Shada Hasan
Oxfordshire County Council,
County Hall,
New Road,
Oxford,
OX1 1ND

Proposal Outline planning application for the construction of up to 140,000 sqm of employment floorspace (use class B8) with ancillary offices and facilities and servicing and infrastructure including new site accesses. Internal roads and footpaths, landscaping including earthworks to create development platforms and bunds, drainage features and other associated works including demolition of the existing farmhouse.

Location Land east of Junction J.11, M40, Banbury

Application No. 23/03428/OUT

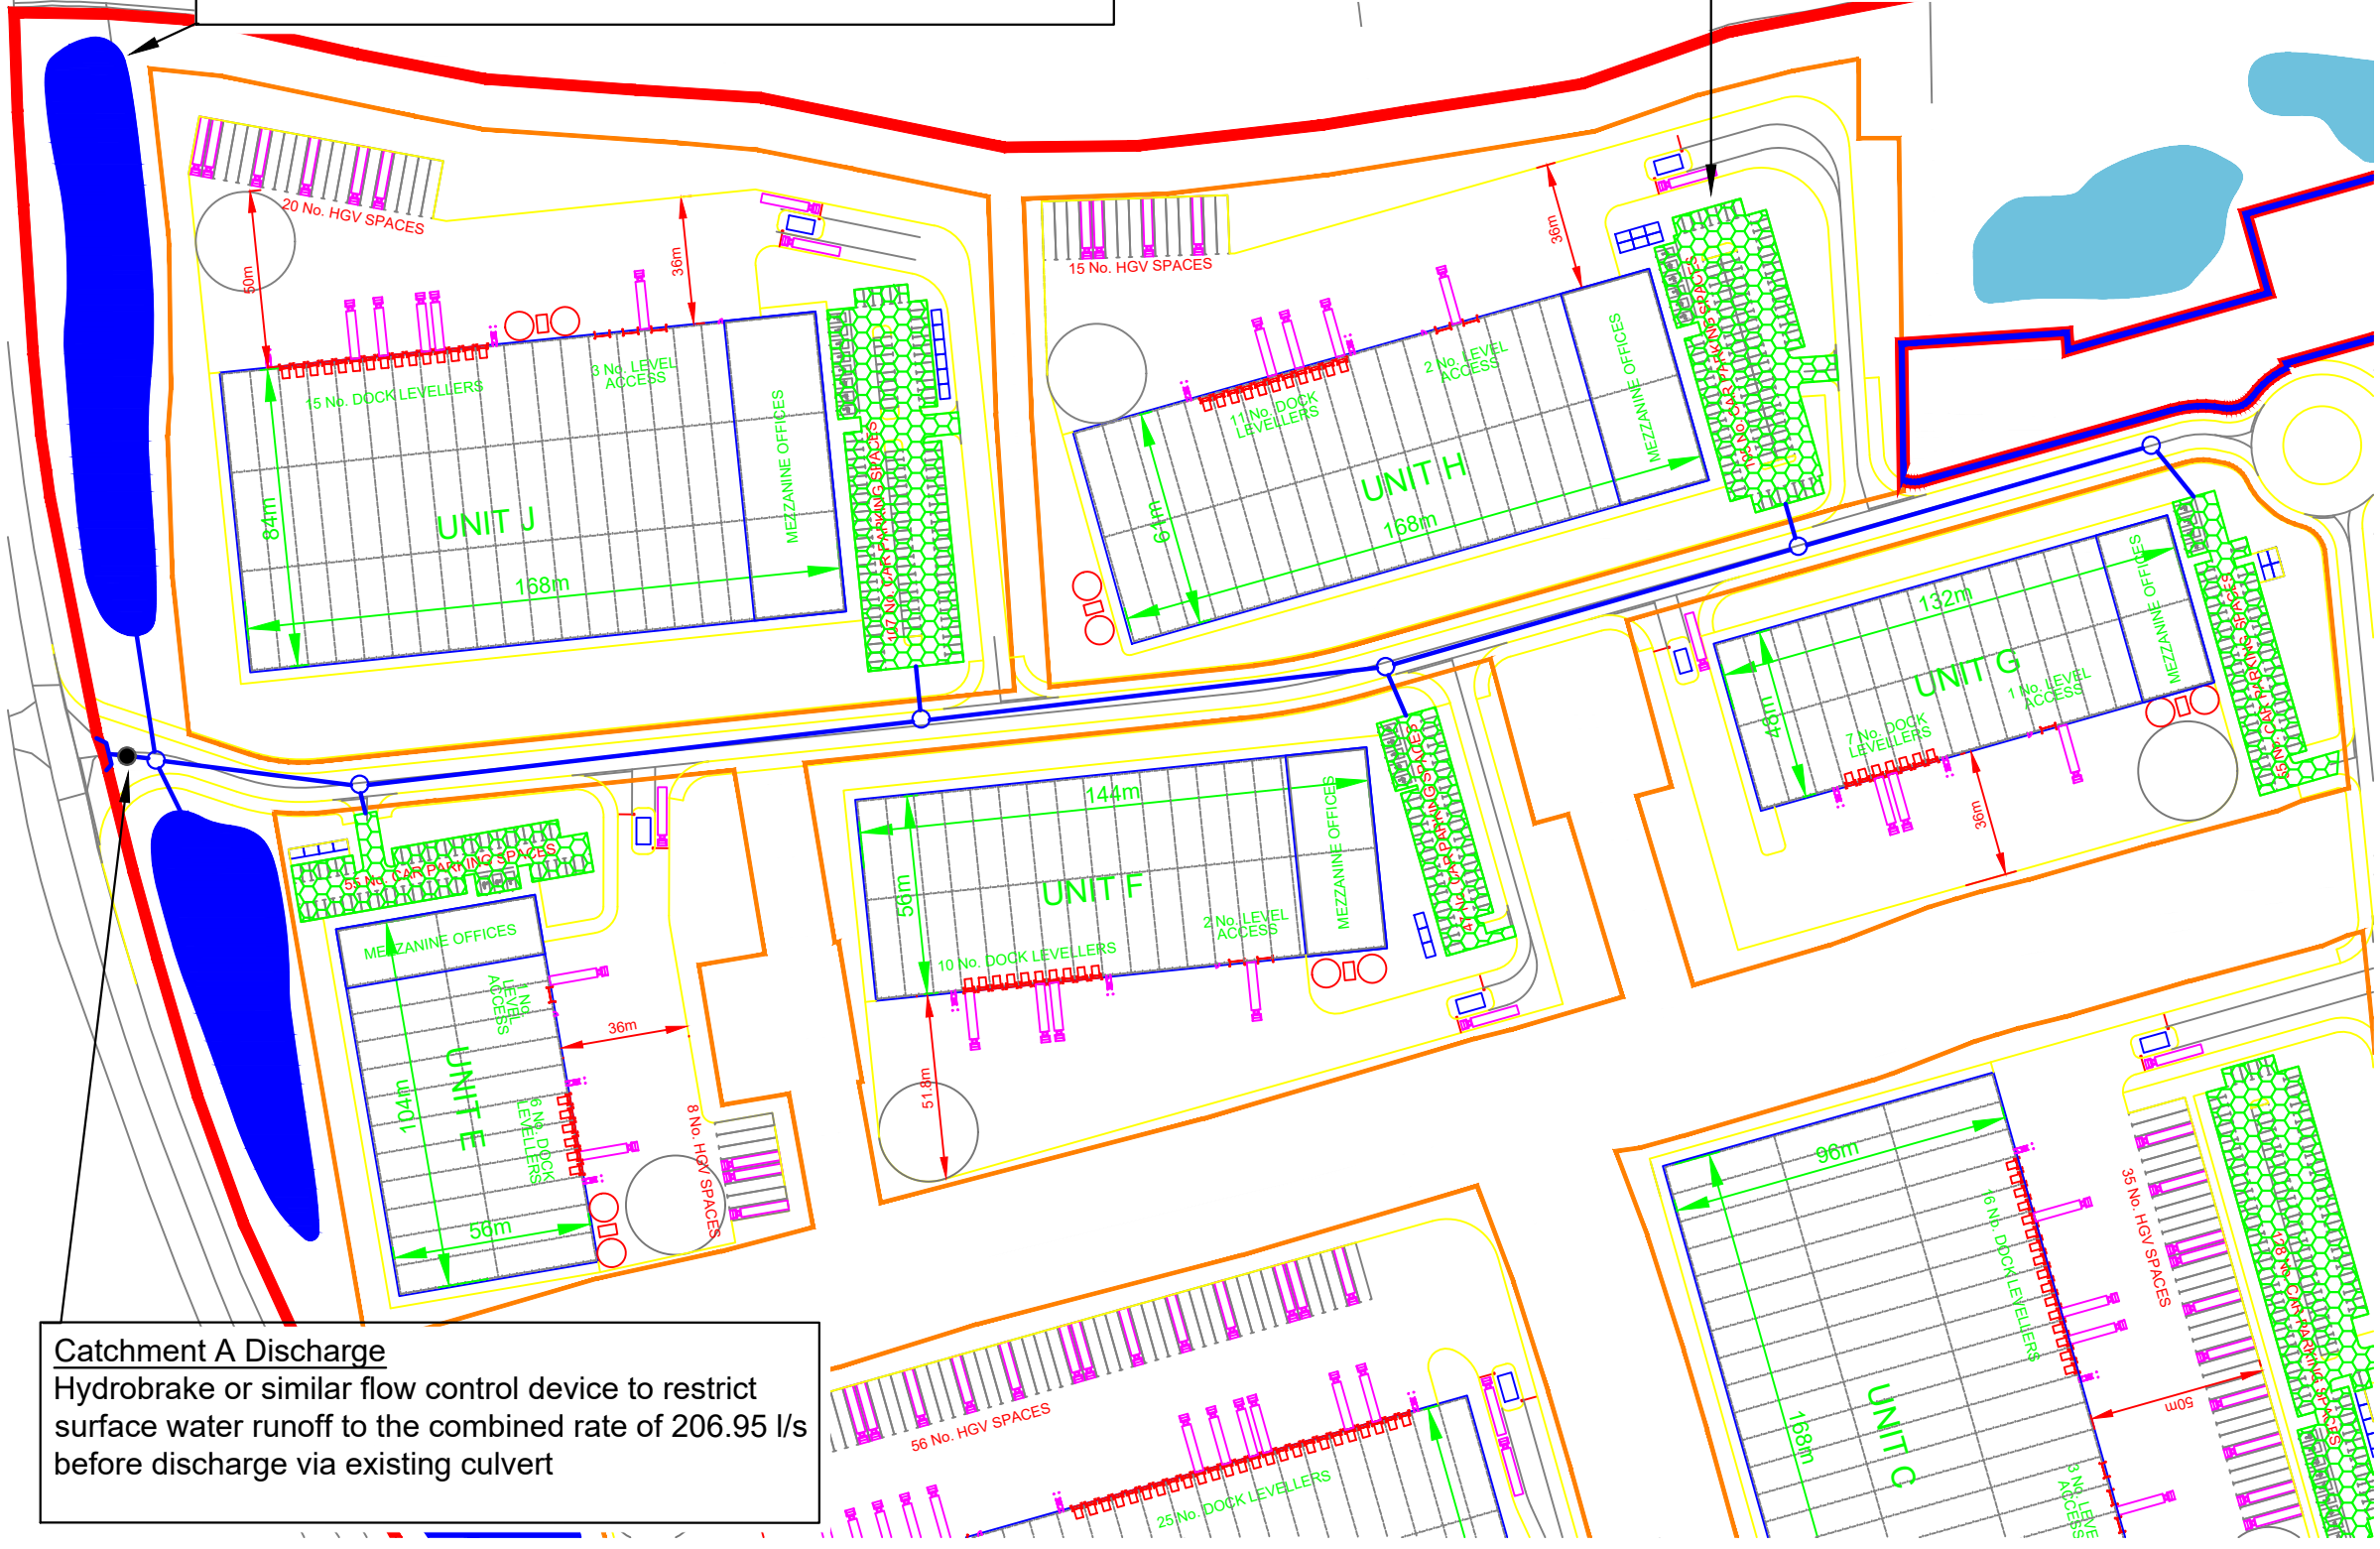
"The FRA explains the surface water drainage strategy however a surface water drainage drawing is required to demonstrate the surface water strategy. Proposed SuDS features and drainage infrastructure needs to be shown indicatively. Outfall locations to be shown, storage details of proposed SuDS features and infiltration rates if applicable".

A Surface Water Drainage Drawing is included in Appendix A of this letter.

As described in the Delta-Simons FRA & DS, surface water runoff will be discharged to the neighbouring site's drainage system and ultimately the River Cherwell via two culverts along the western Site boundary at a combined maximum rate of 460.51 l/s.

Surface water runoff up to the 1 in 100 year plus 40% climate change allowance event will be attenuated on site. A total attenuation volume of 21,526 m³ will be required to achieve the discharge rate and will be provided in the form of ponds, swales or detention basins located in the west of the Site and also within permeable paving.

The Drainage Drawings shows that the require amount of attenuation is available within the car parking areas and the proposed ponds within the north-western extent and within the demise of the southern plots.

Drawing
**Conceptual Drainage Sketch
Catchment A Area**

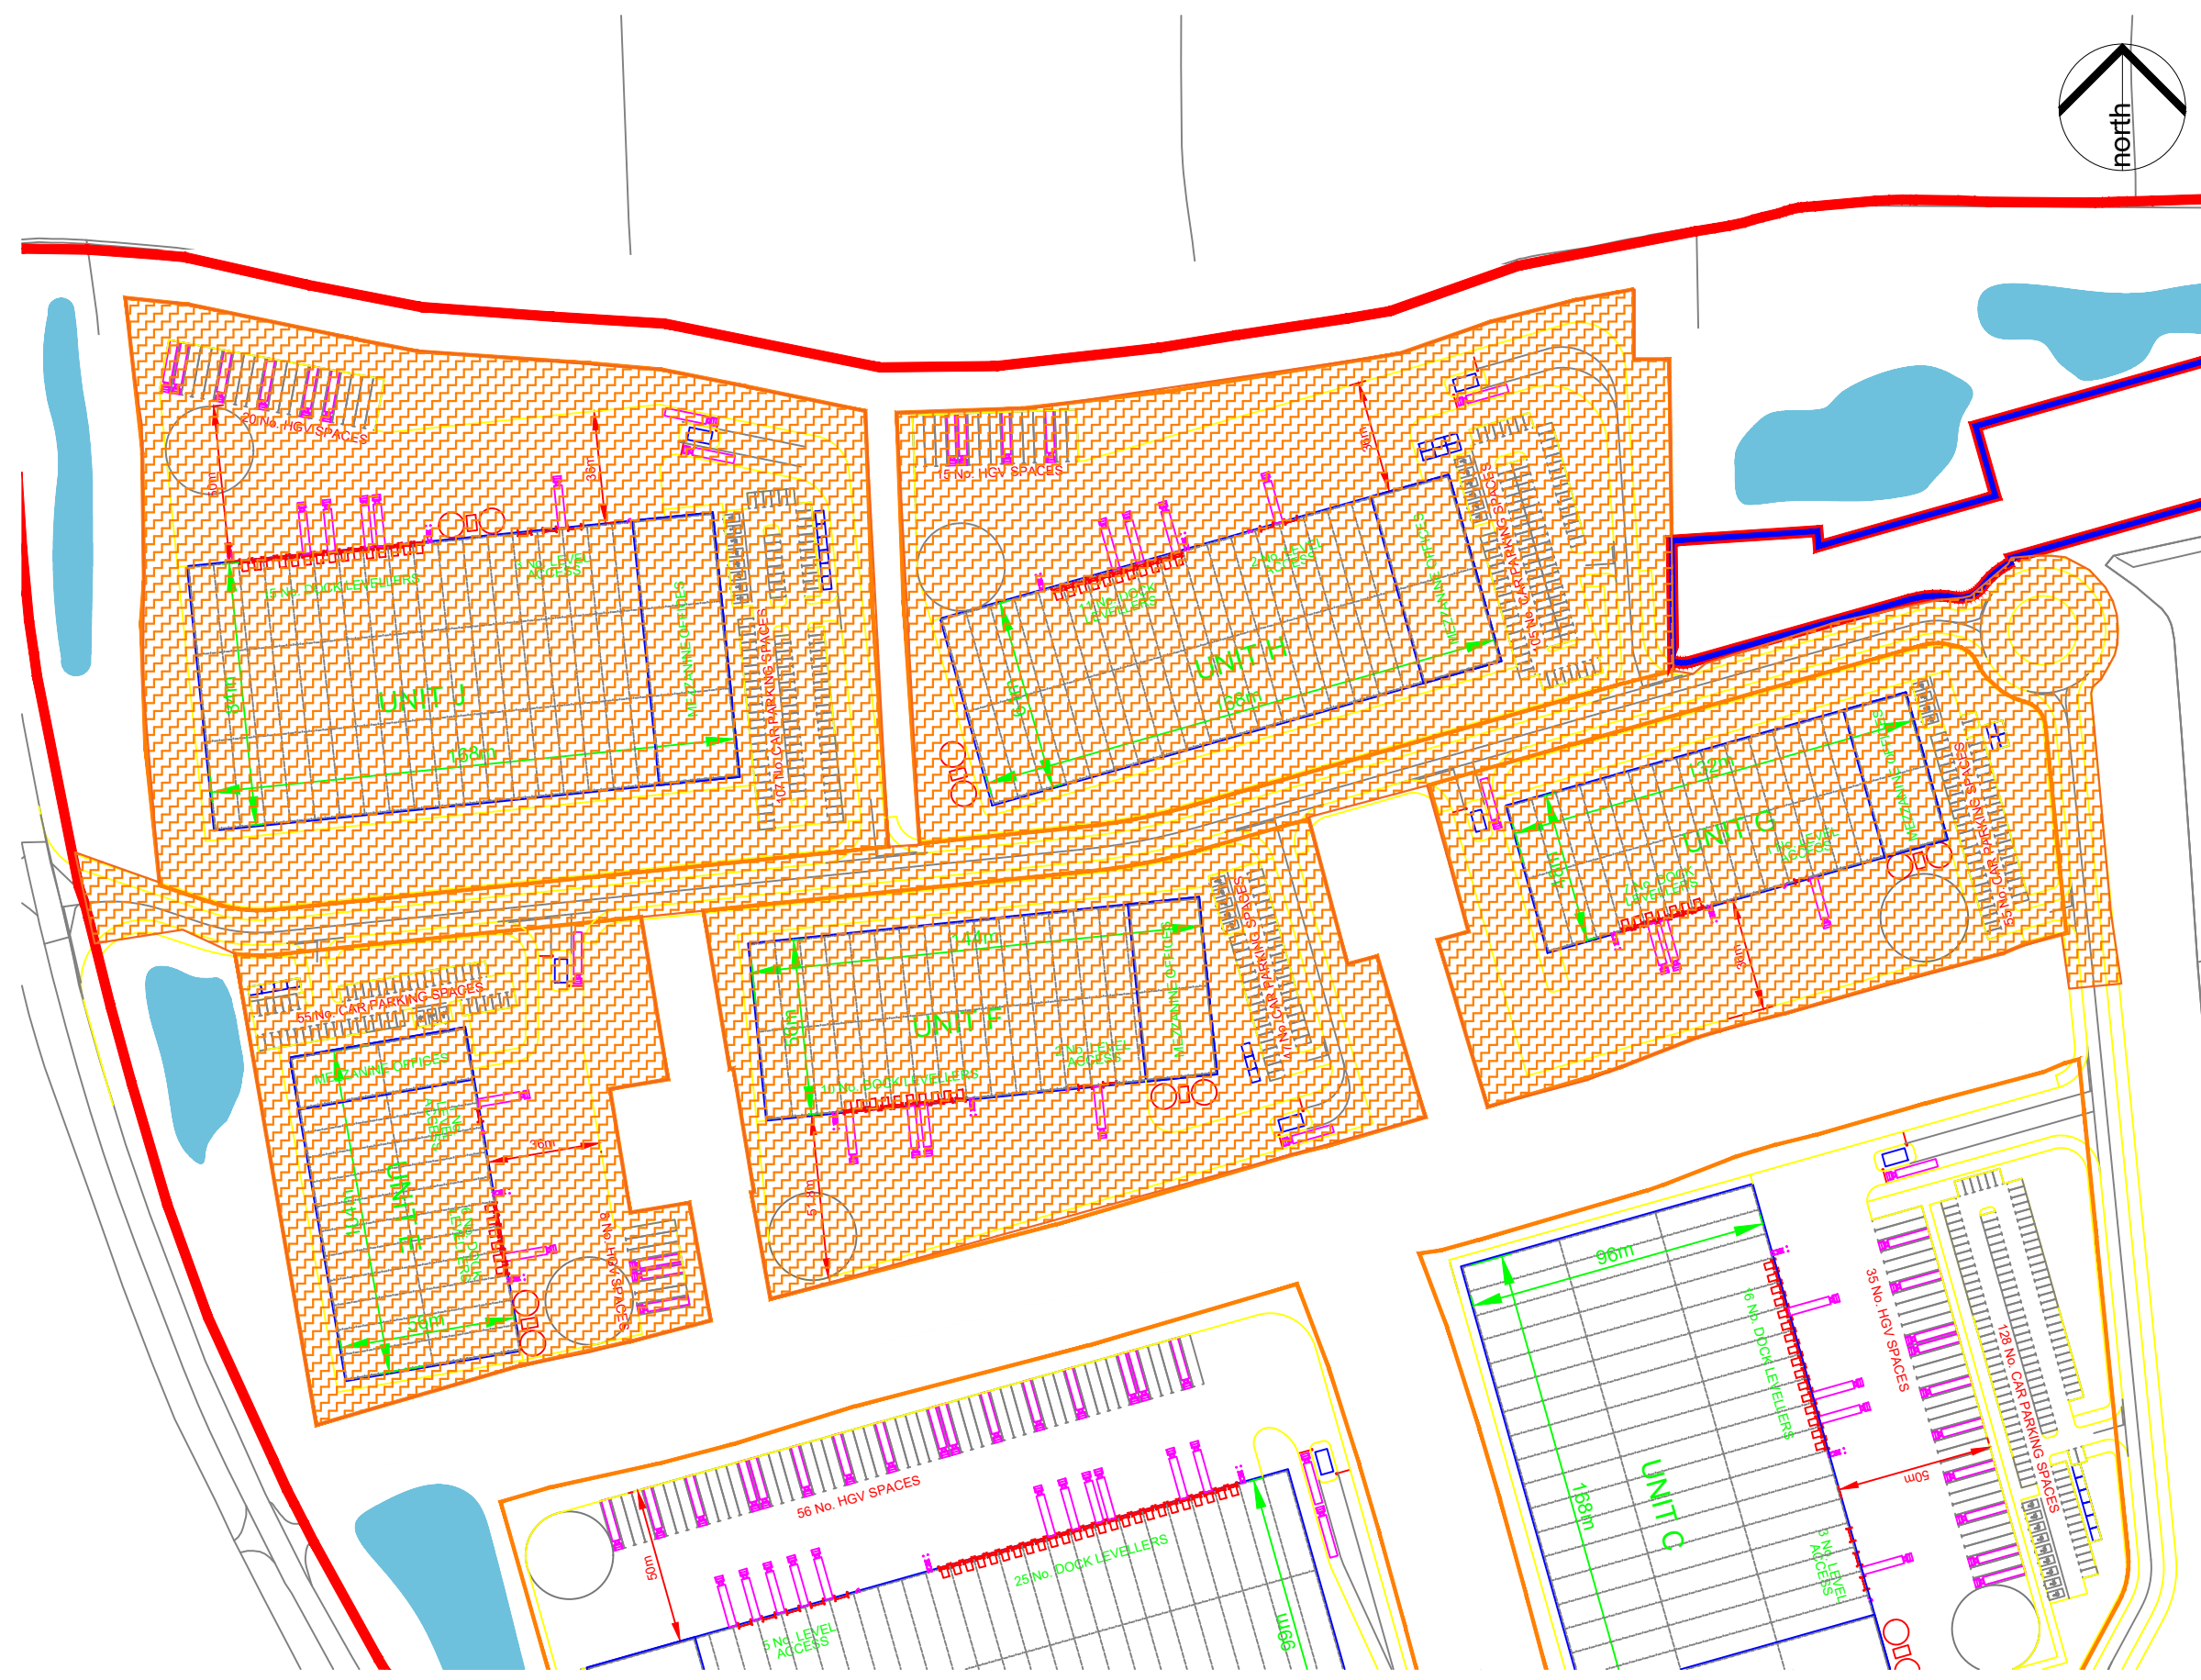
“The catchment areas have been broken down in the FRA, however a Catchment plan is required to highlight the extent of the areas. Stating the total impermeable area and the impermeable area including urban creep”.

A Catchment Plan is included in Appendix B of this letter.

The site can be split into two catchments each served by the two existing culverts at the lowest extents of the site. The site can be further split into individual plot catchments at the detailed design stage if required. It is reiterated that the layout is not fixed, and the catchment areas may change as a result of works undertaken at the detailed stage.

Area (m ²)	Discharge Rate (l/s)
Catchment A	143,060	206.9
Catchment B	175,287	253.56
